BR/27/19/HH

The proposal is to replace an existing garage door with a French window in order to facilitate the change of use of the space to residential accommodation.

Martyn White | Principal Conservation Officer, Planning Policy, Directorate of Place, Arun District Council | Location: First Floor, Arun Civic Centre, Maltravers Road, Littlehampton, BN17 5LE

PROPOSED FRONT ELEVATION

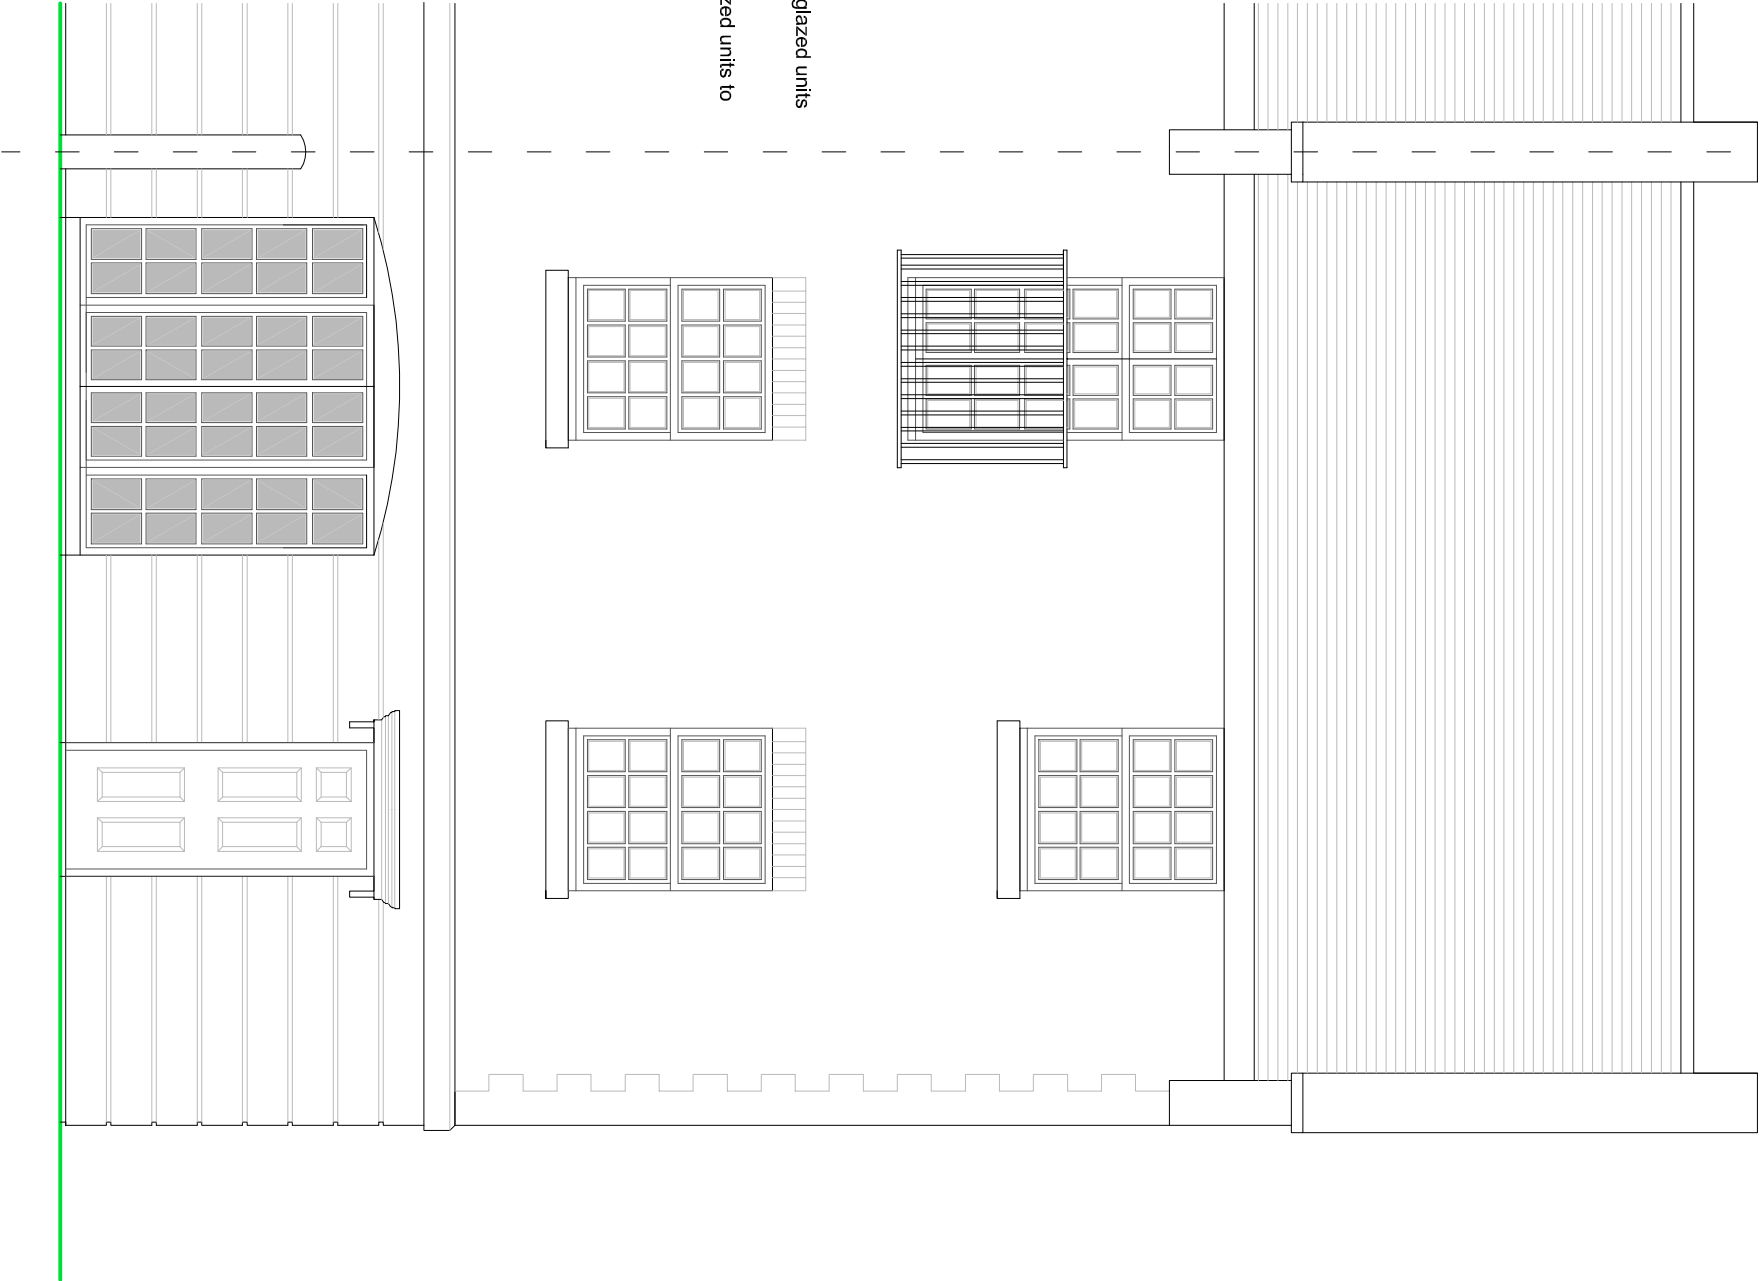
The proposed French doors will be constructed in timber in a design that appears to match the existing joinery within the property/terrace. Such an approach is supported.

Therefore, on balance, it is considered that the proposed French doors will have a neutral impact upon the character and appearance of the local area, and can be supported.
